CONSTRUCTION PLANS
FOR
THE RIDGE AT LORSON RANCH FILING NO. 2

STREET & STORM SEWER CONSTRUCTION PLANS

**THE RIDGE AT LORSON RANCH FIL NO. 2
STREET & STORM SEWER
CONSTRUCTION PLANS**

**TYPICAL SECTIONS**

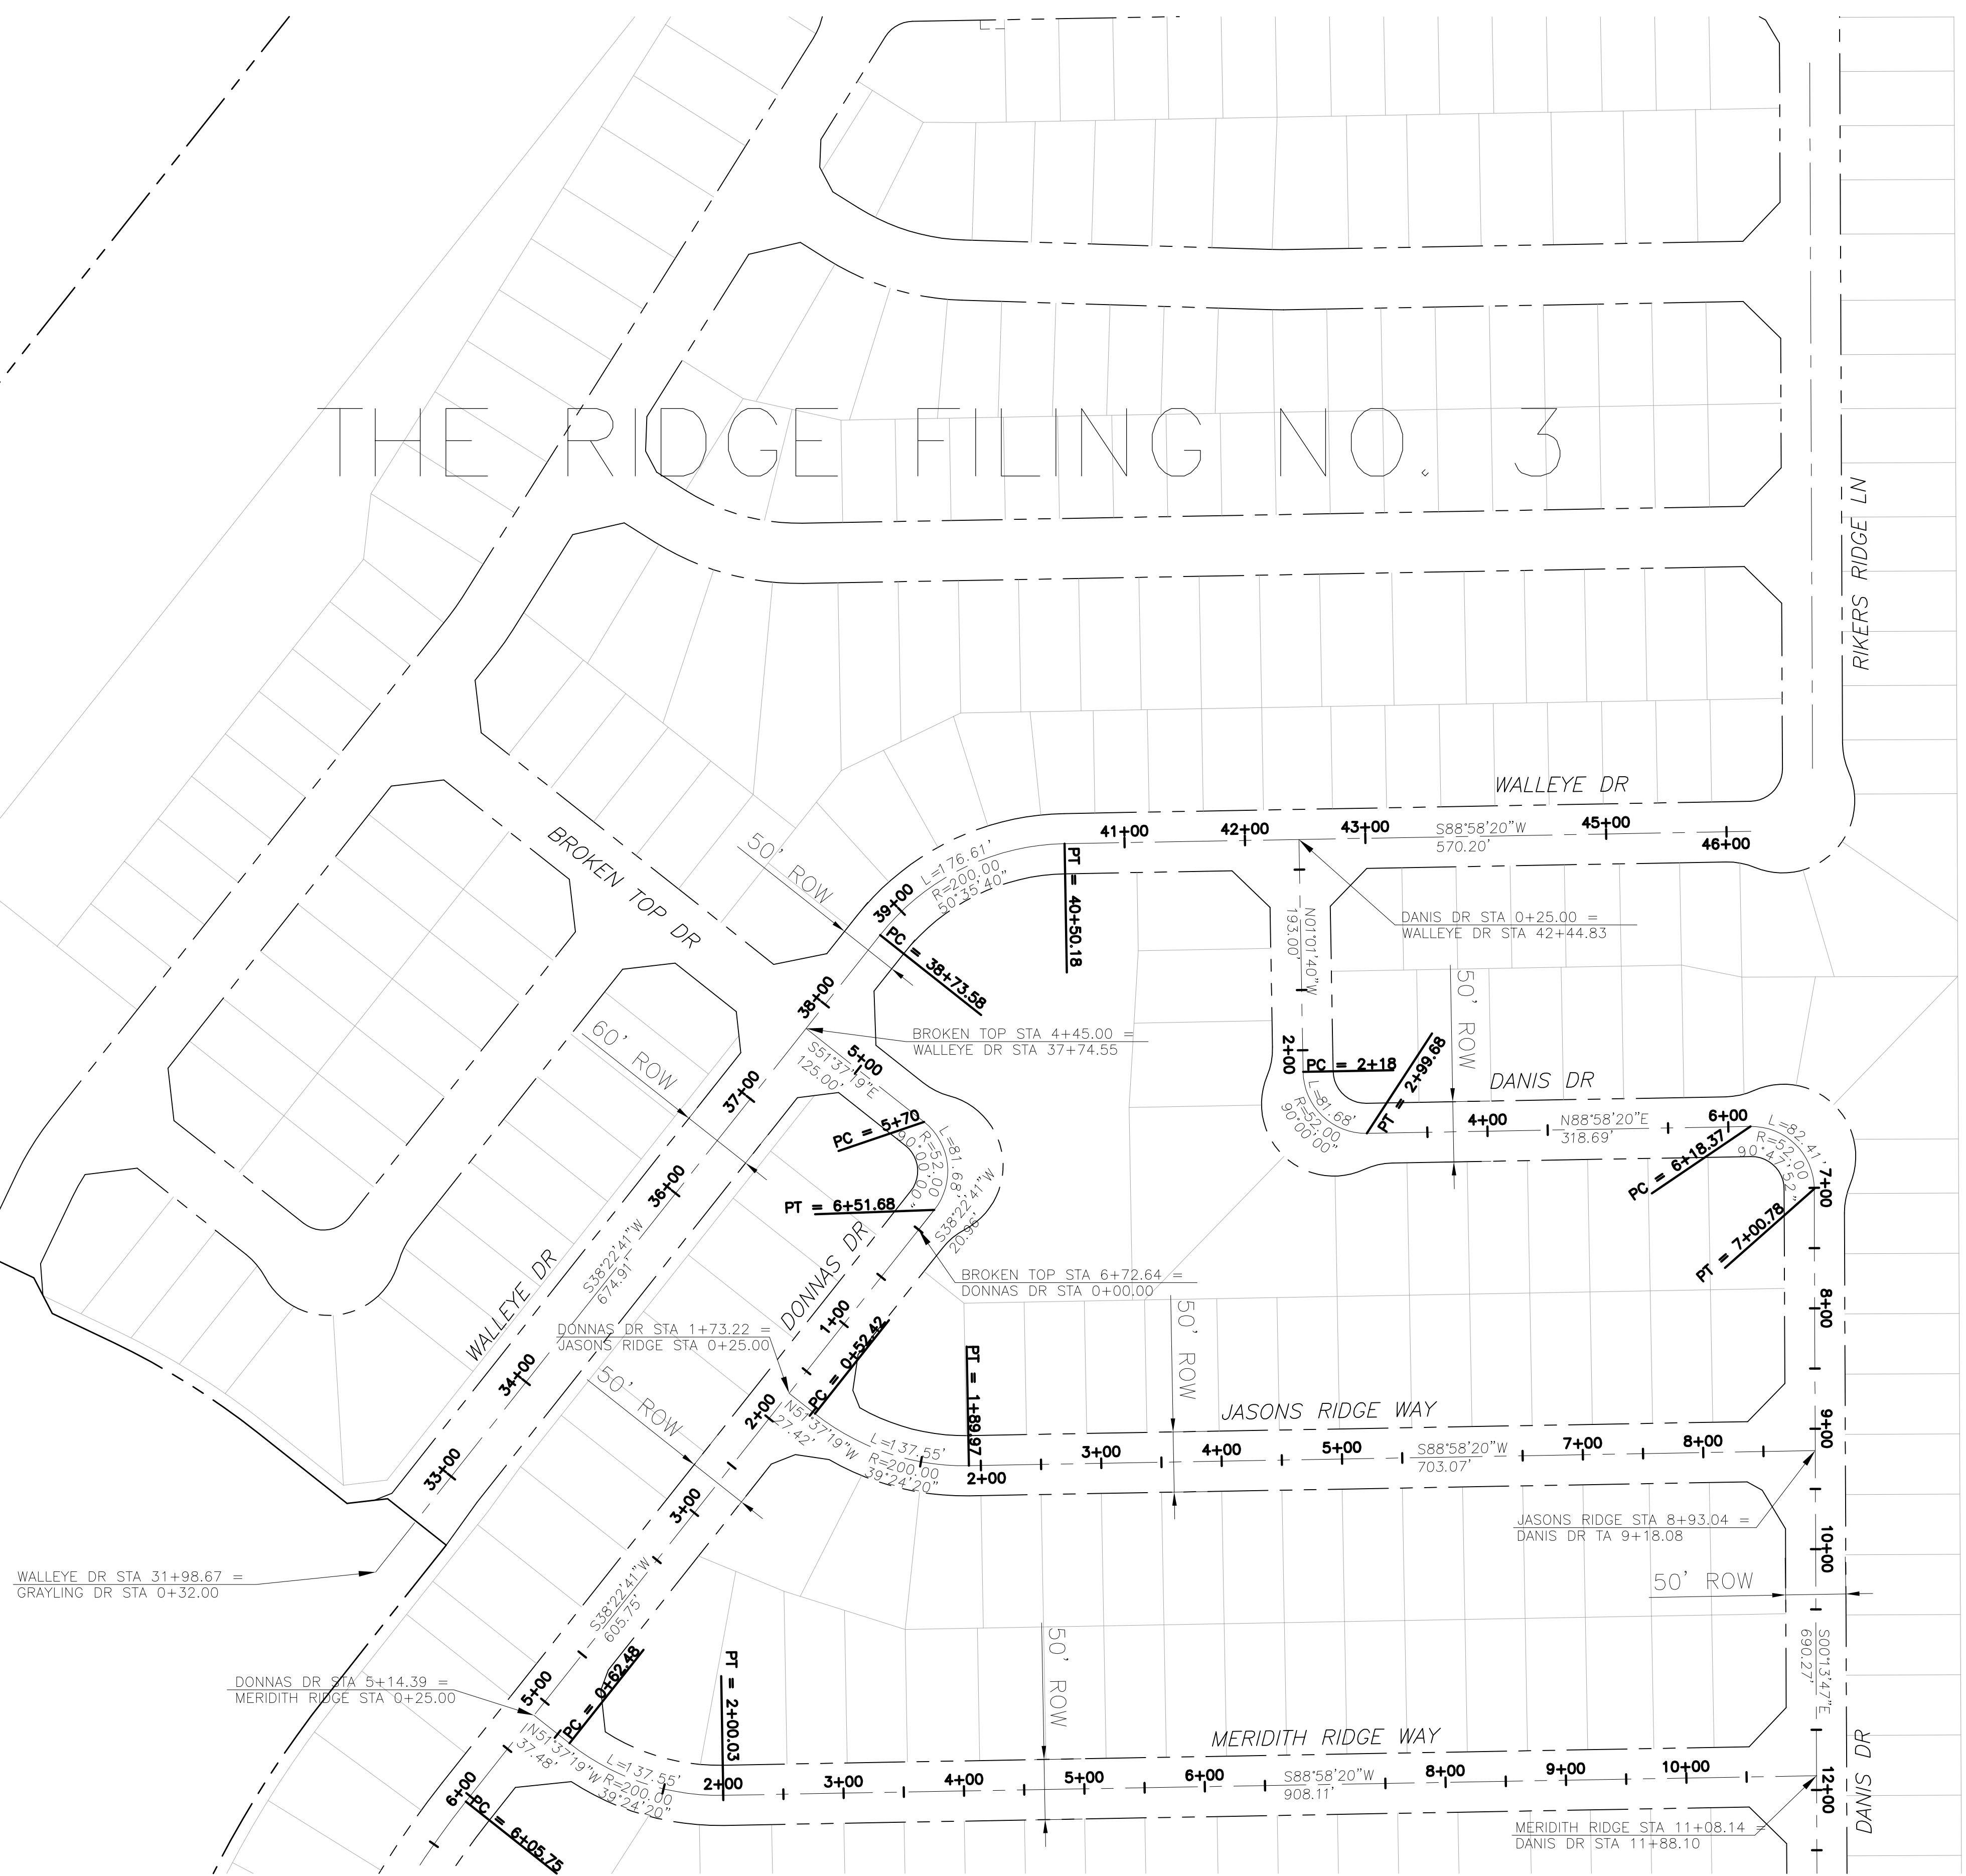
According to
comment responses,
Walleye was
downgraded to a local
street. Please revise
and update posted
and design speeds.
